GEC Plan Comments 2.pdf Markup Summary

[10] S1183-A-01-010 (2)

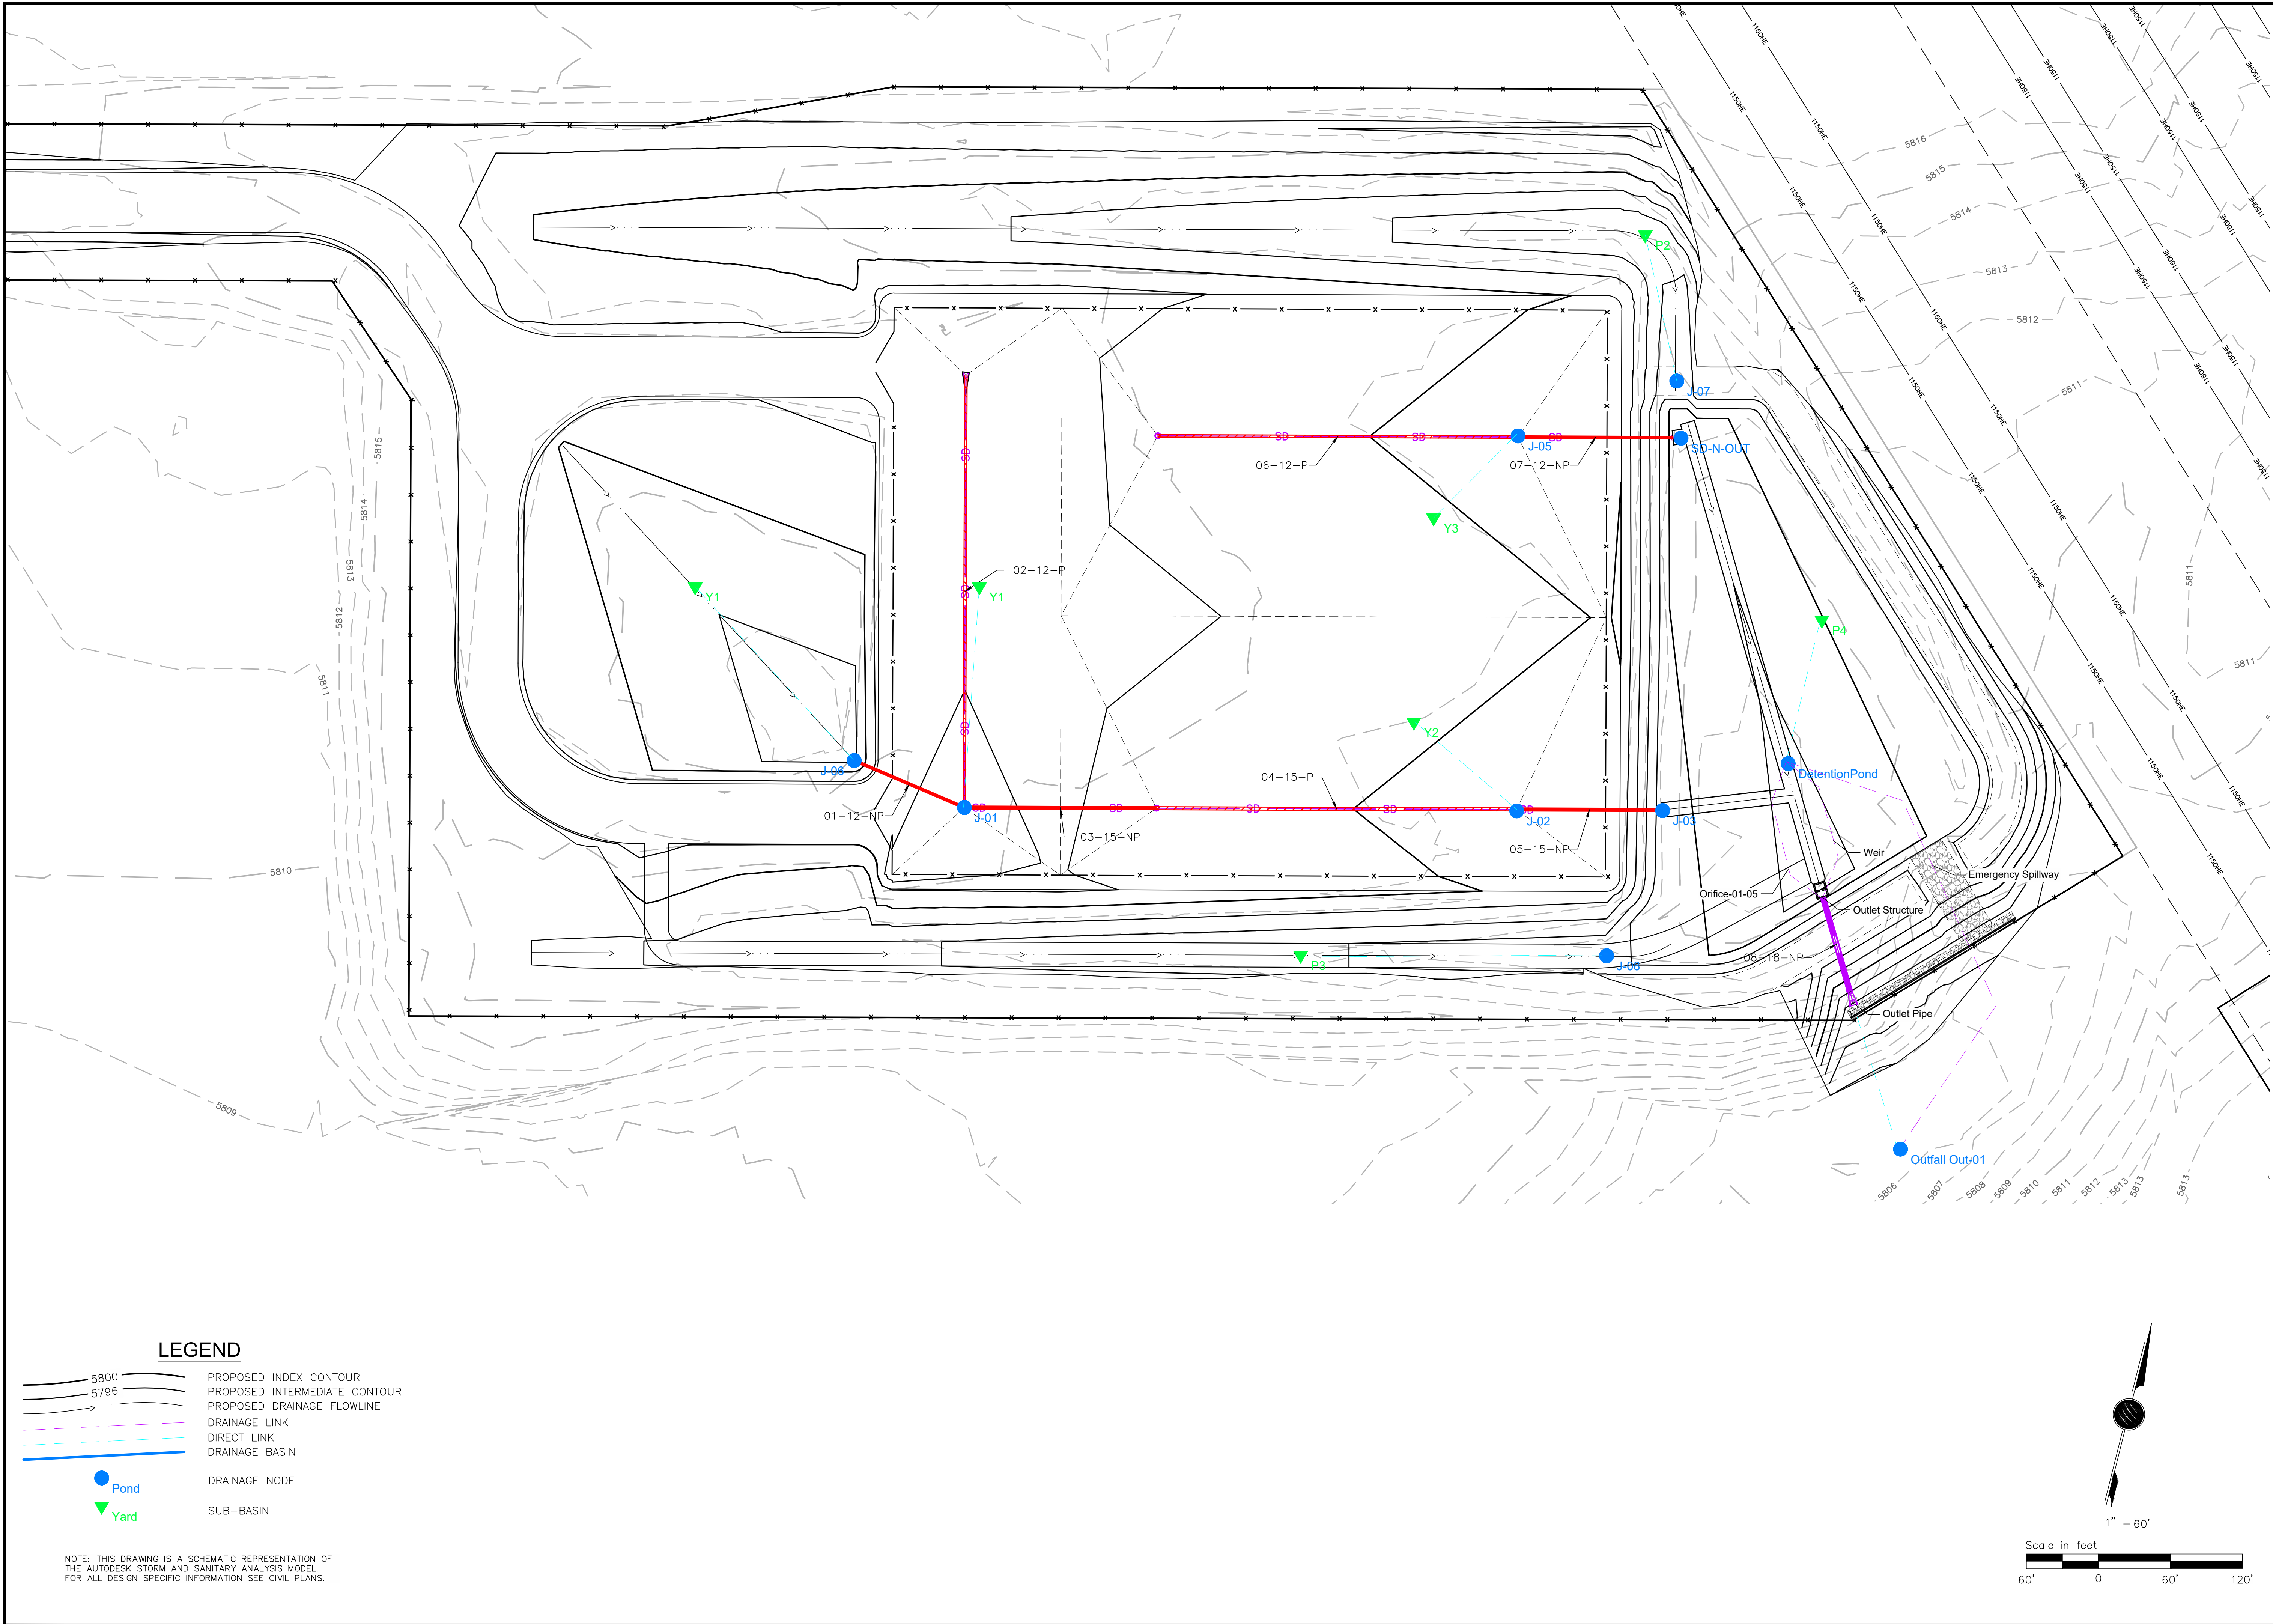
Per calcs this should be 5811.1. The calcs show the spillway invert at 3.08 ft from stage = 0 (3808.02).

DMC RESPONSE: Elevations have been updated to 5811.10'

DMC RESPONSE: Elevations have been updated to 5811.10', the MHFD calcs are correct
